From: TONY PHEBEY [REDACTED]
Sent: 10 September 2019 13:44
To: Finlay Gardner <Finlay.Gardner@arun.gov.uk>
Subject: RE: Application BR/178/19/PL

I have recently taken over your application BR/178/19/PL (Delawarr House, Flat 1). I am emailing with a few questions about the proposed plans. In the larger flat the bedroom appears to not have any direct access to daylight. Would there be a possibility of a window in the dressing room?
Any information you can give me will be greatly appreciated.

PROPOSED FIRST FLOOR PLAN/ROOF PLAN
Scale 1:50

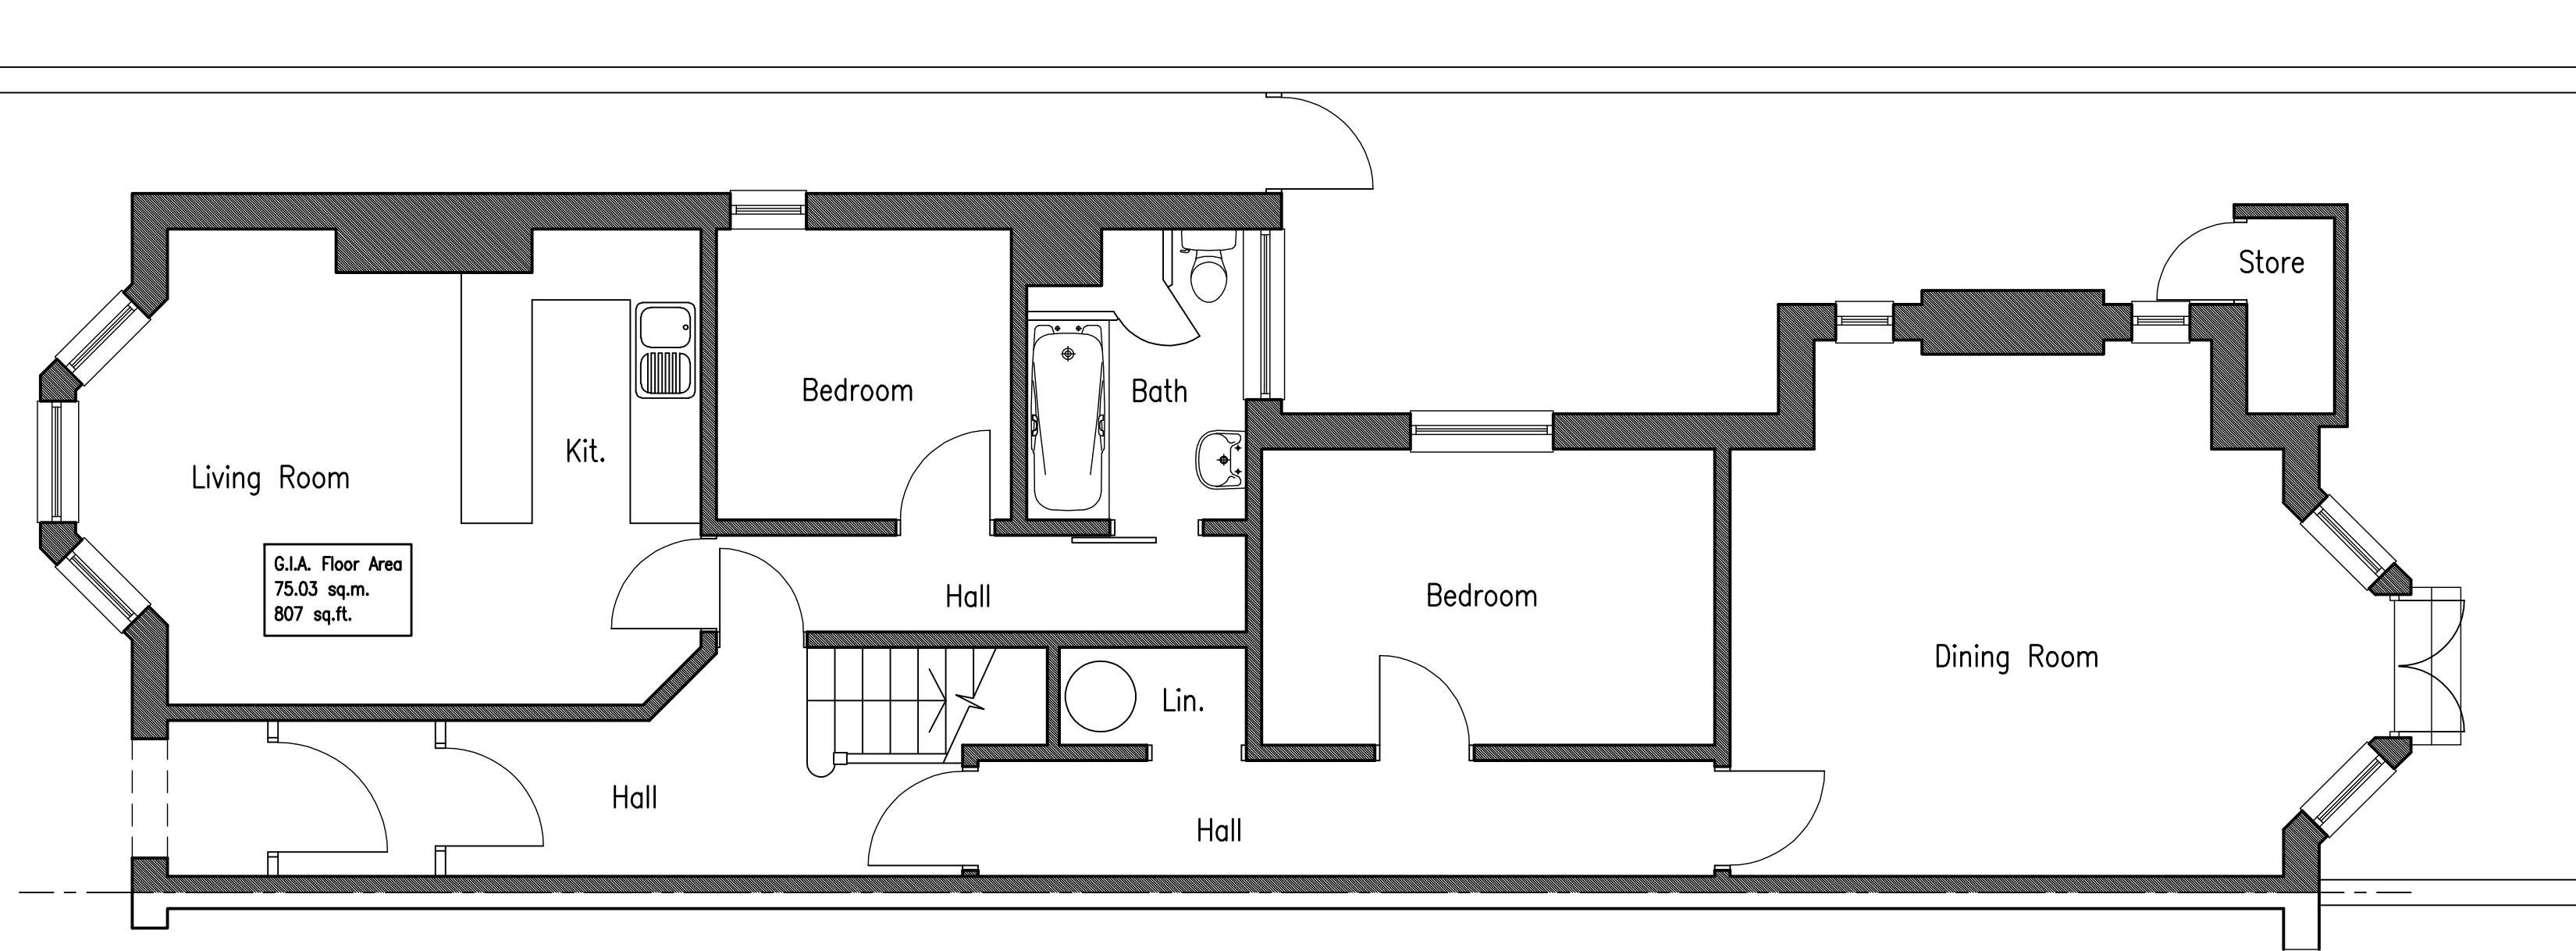
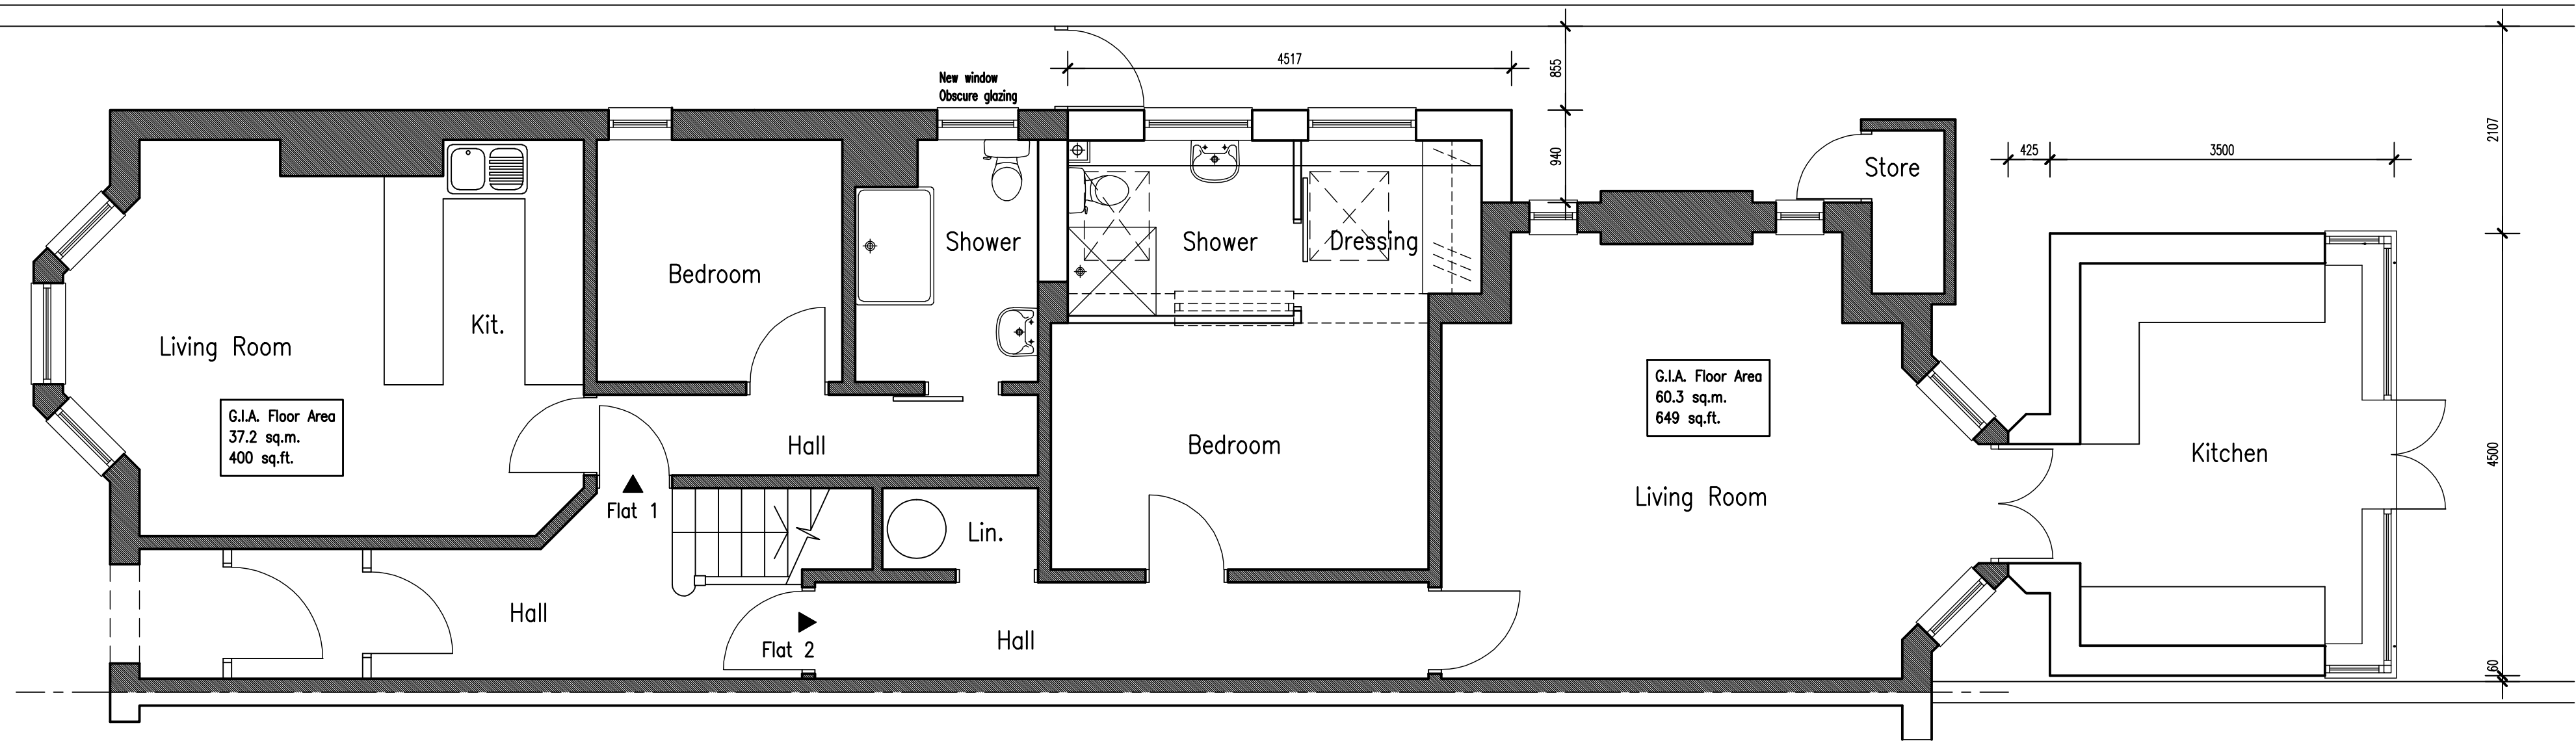
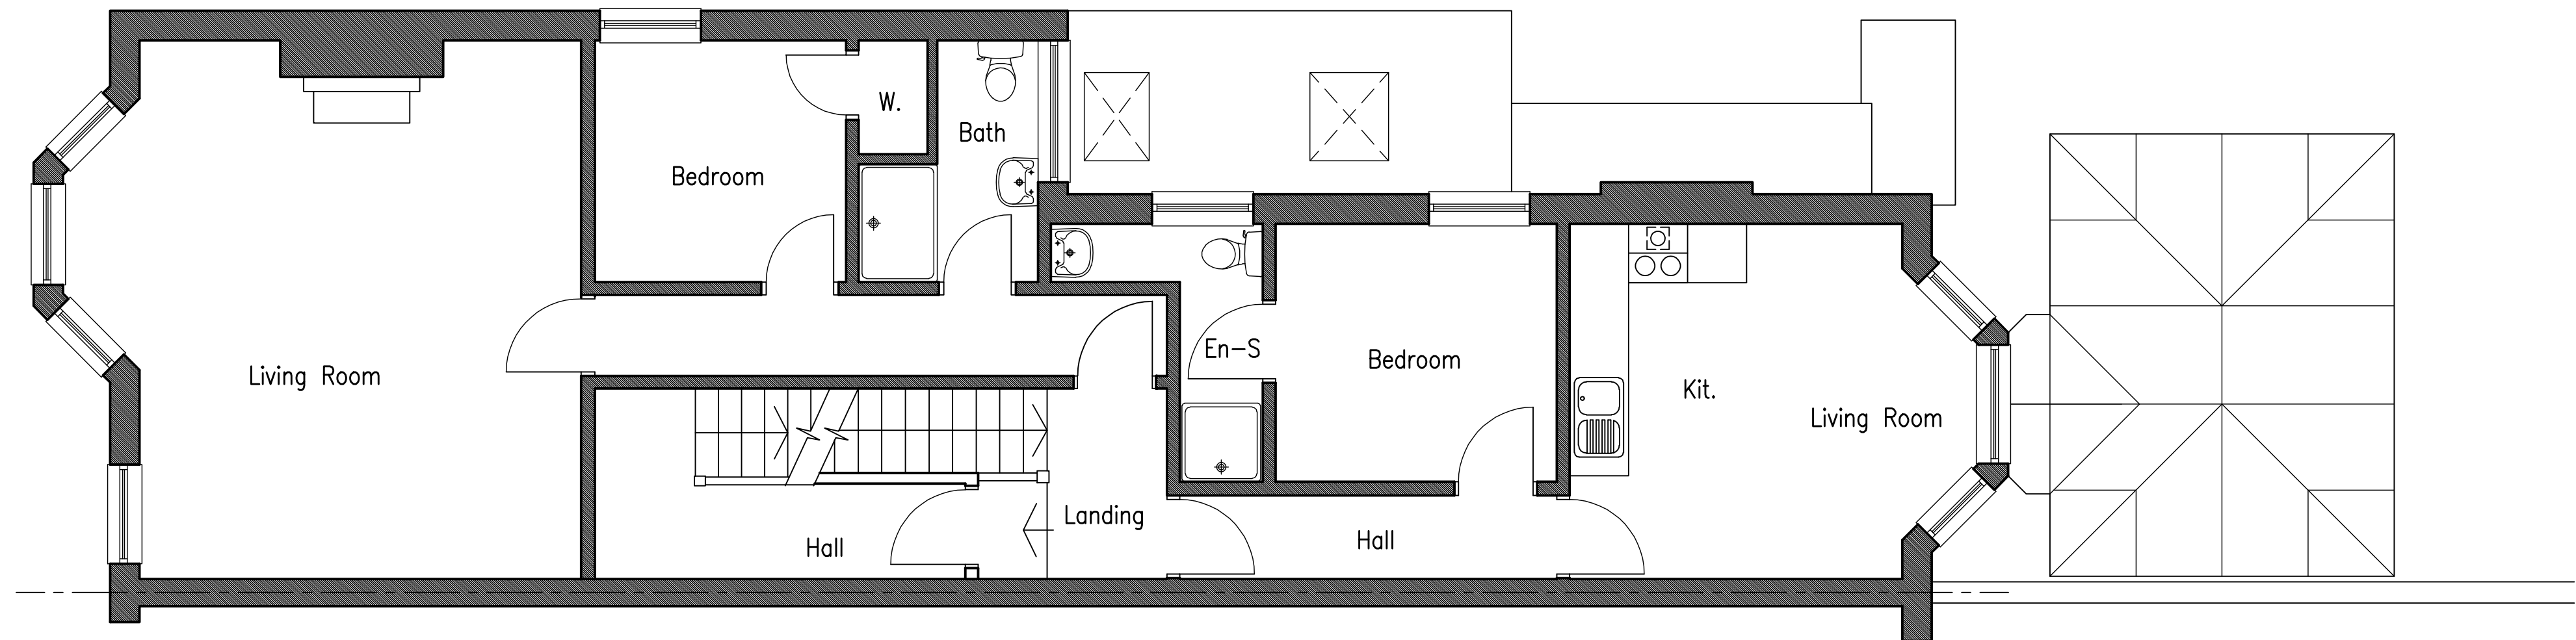
The issue that we find with the sky light is that it is not direct light into the bedroom, the way we would see to overcome this is to have a window in the dressing room, is this a possibility?

Further to your earlier e-mail please find attached amended planning drawings showing an additional window to the side extension bedroom as requested.
